Subject: FW: LU/134/21/PL & LU/135/21/L The Farm, East Street, Littlehampton - FIREPLACE WORKS

Pls add below email and attached image to case files x 2 as above and label as 'GF Fireplace/FF chimney breast proposals'

Drawing Name
Cellar, Ground Floor and First Floor Plans - Proposed

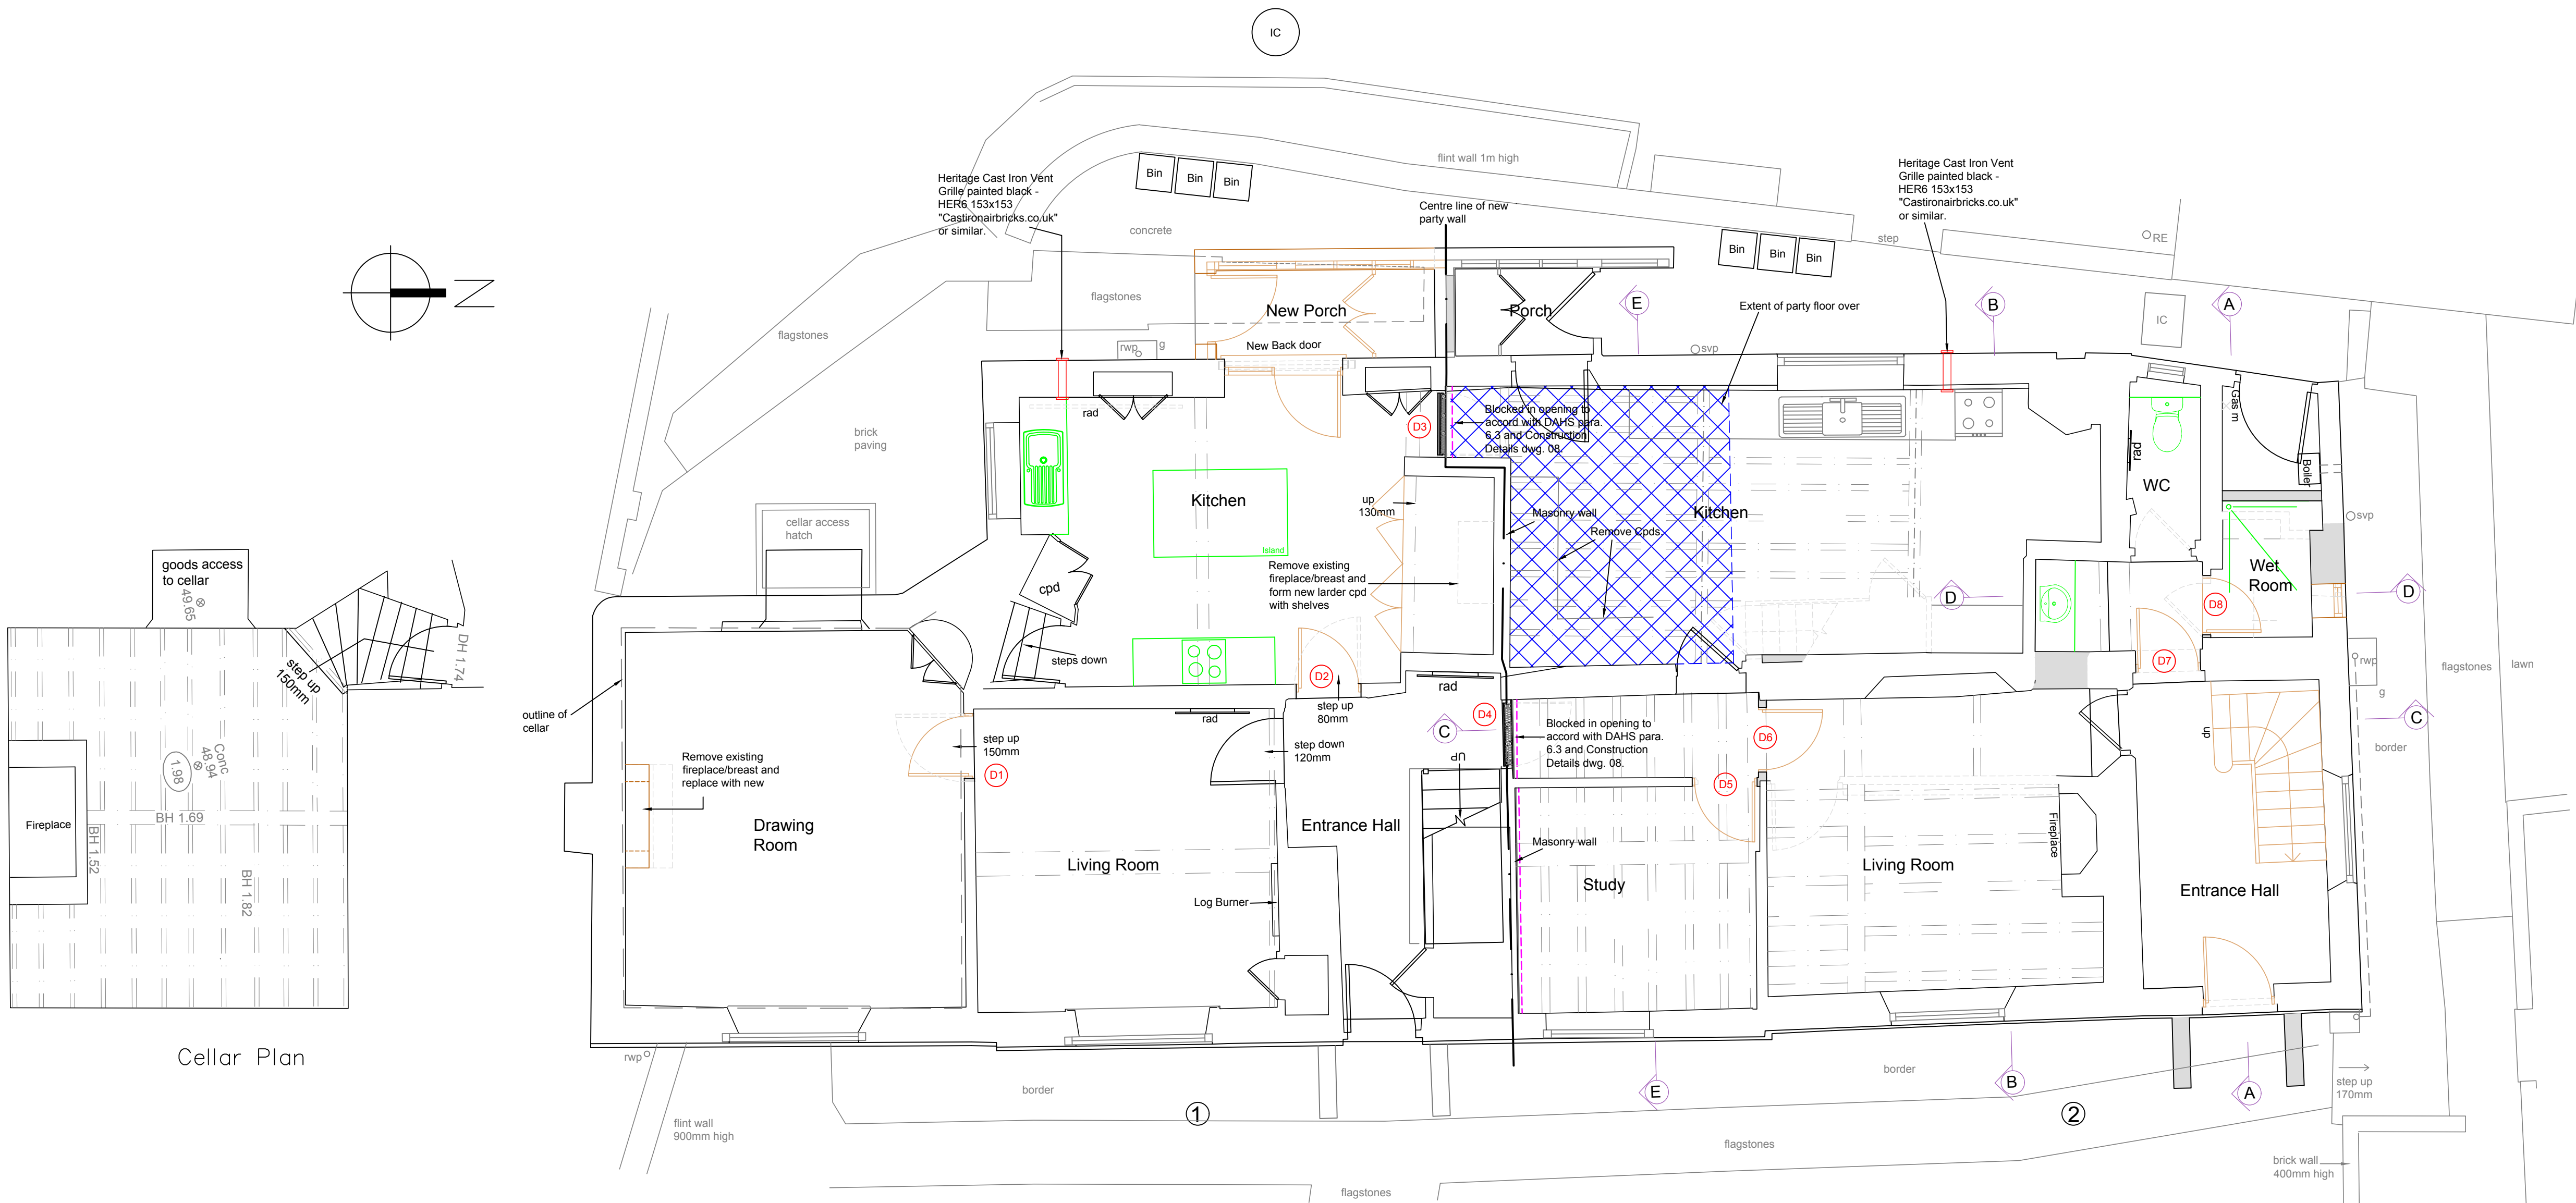
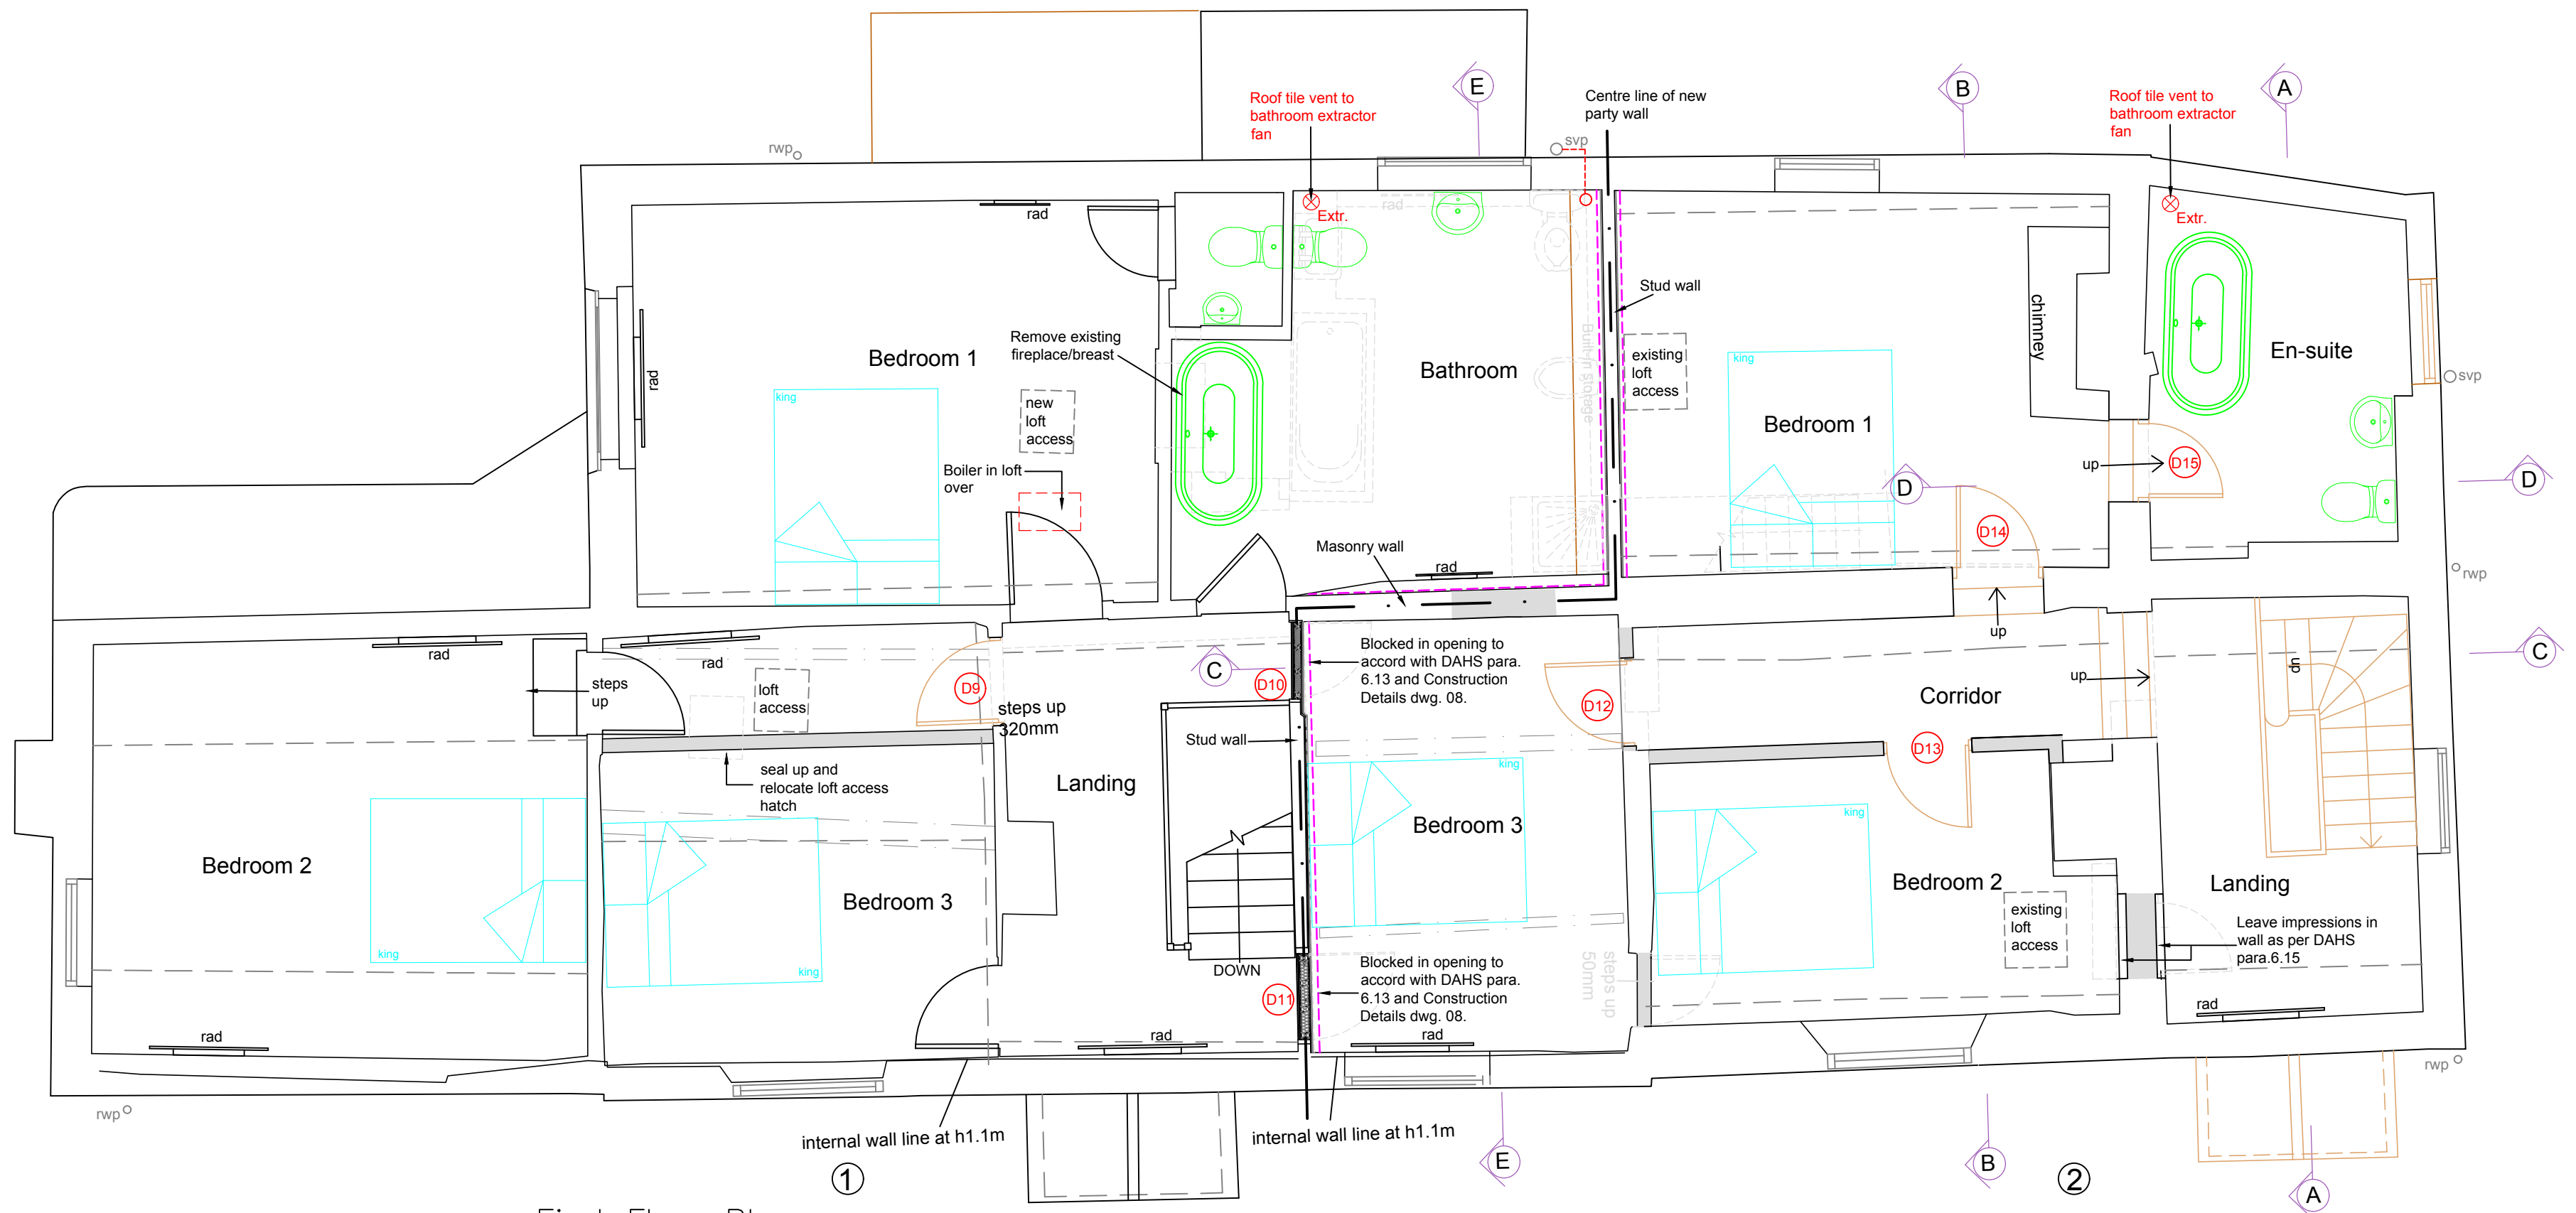
Why is there loss of the fireplace/chimney breast at the first floor level in the existing bathroom. It is not clear why this has to be removed, and ideally it would be retained?

In respect to your concern over the loss of the fireplace / chimney breast in the bathroom, I have discussed this with our clients, and confirm they are happy that it is retained. The existing fireplace is a later addition(please see attached image). The proposal is now to simply remove this more recently added fireplace at ground floor to bring it back to the original form, as shown in a picture in the attached document, and the larder to be built around it and retain the structure above.
